Application No: BR/56/14/

Recommendation Report for Planning Permission

LOCATION: Land on the Promenade
Near the Foreshore Station
Bognor Regis

PROPOSAL: Charity Wishing Well

PROPOSED WISHING WELL
FOR ROTARY CLUB OF BOGNOR HOTHAM
AND THE ROTARY CLUBS OF BOGNOR REGIS
SCALE 1:20 FEB 2014
A 01

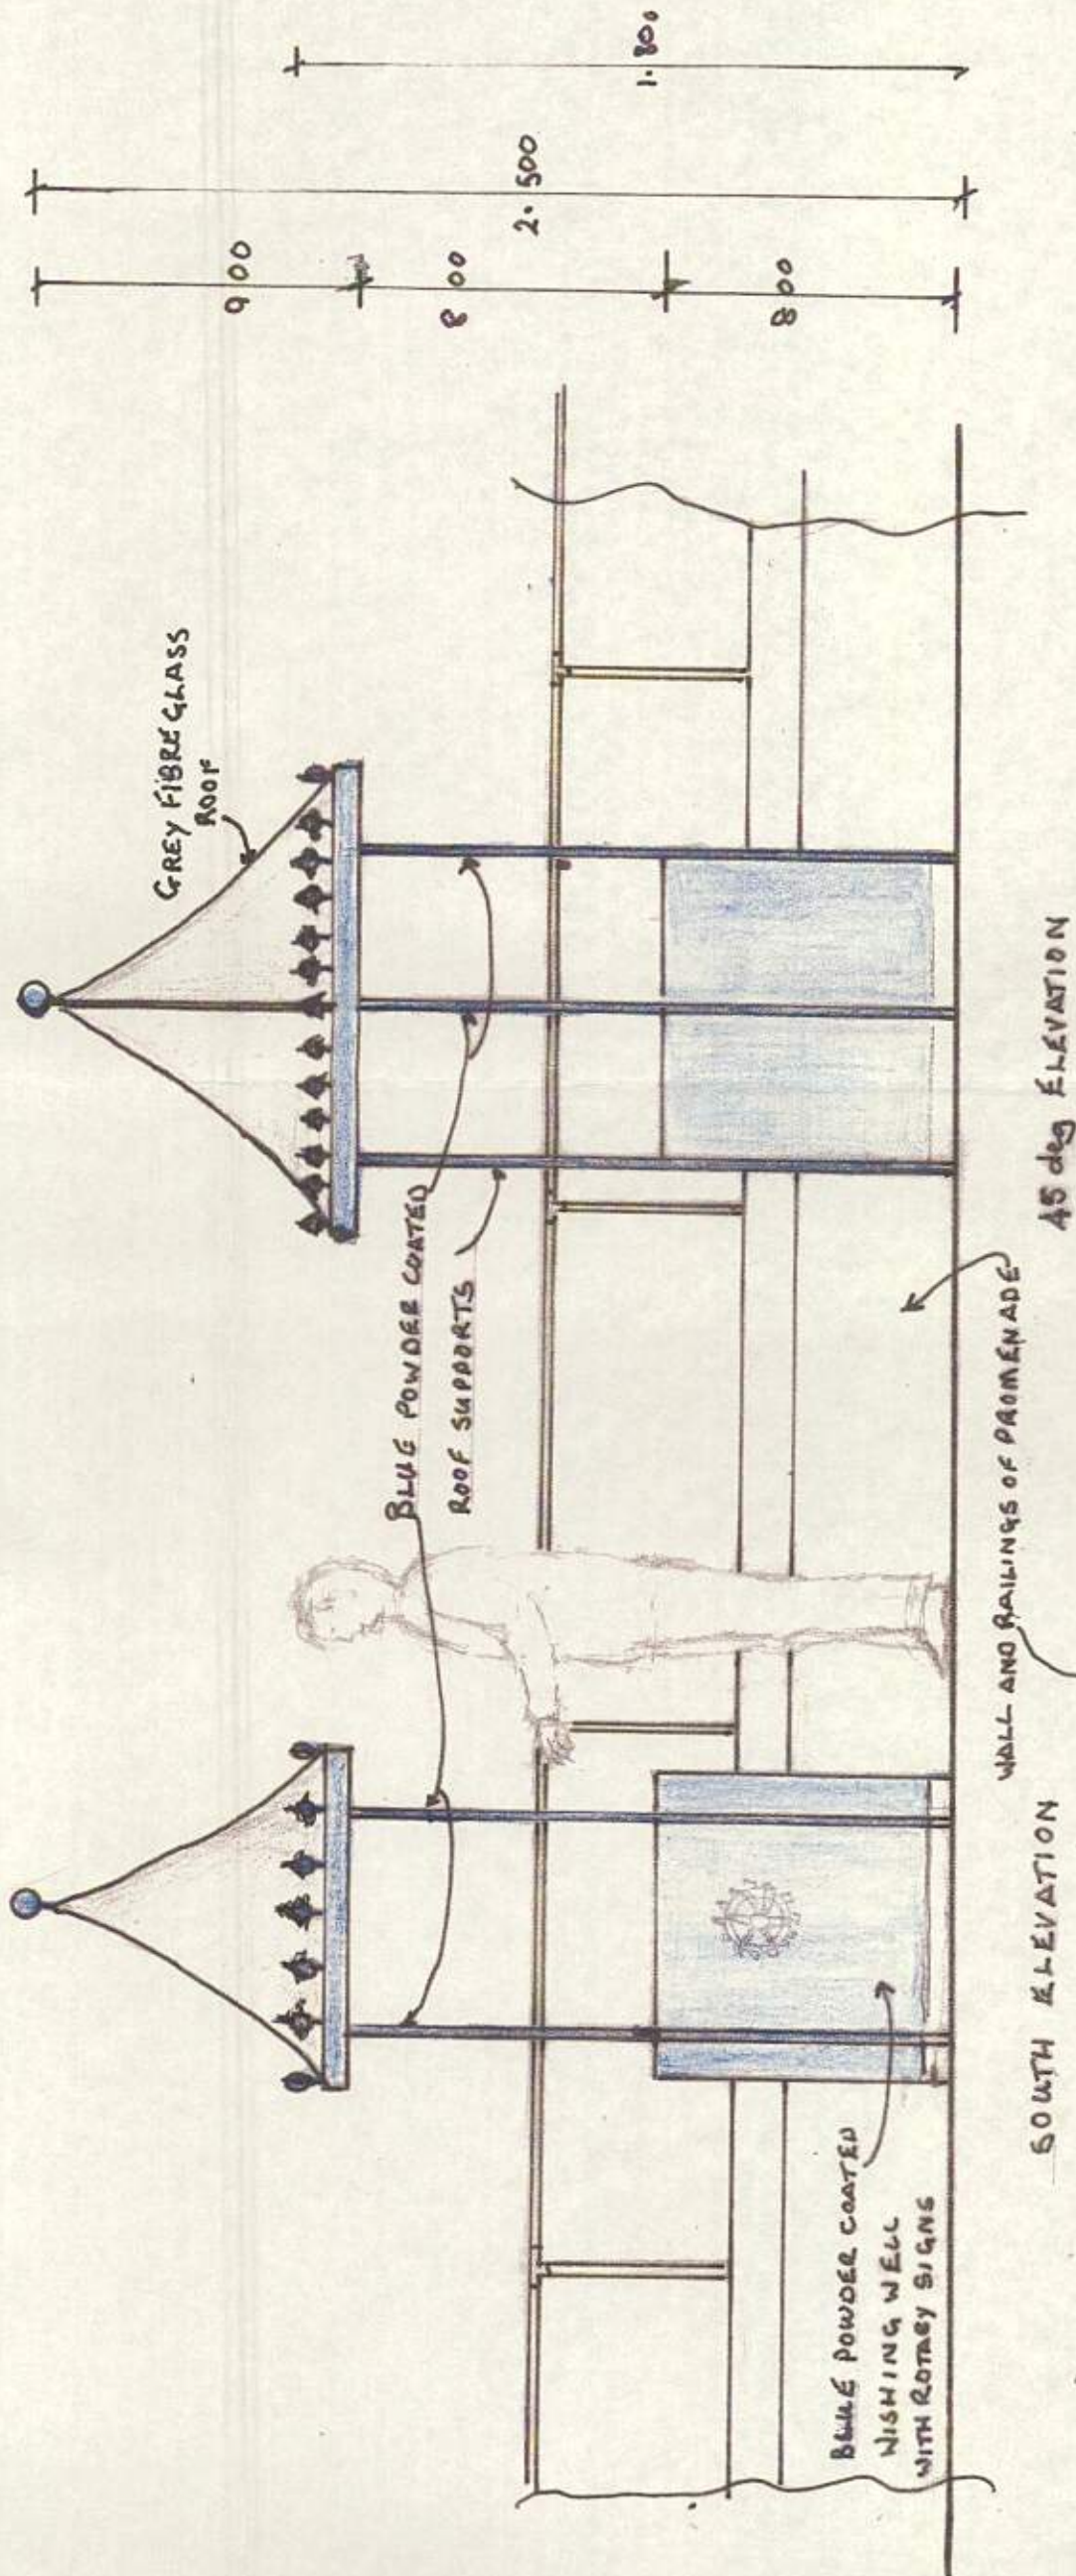
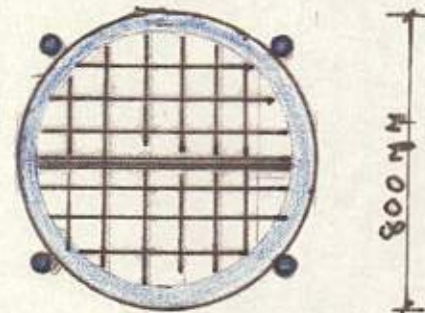
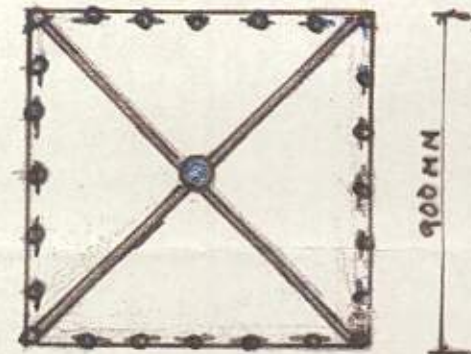
Bognor Regis Town Council objection: Concerned at impact a well would have on the appearance of the seafront area as this had the potential to make the street scene appear cluttered. Concerns were also raised that the well may encourage littering and attract other anti-social behaviour. Comment was made that if this application was accepted, it may even set a precedent for others to apply for something similar. The Committee were keen to highlight the fact that the Town Council does support the work of the Lions Club.

Objection noted. The impact of the notice is considered in the main report and the recommendation of the report is not changed as a result of the representation.

The Council as landowner have the power to control other structures through both planning and landlord controls.
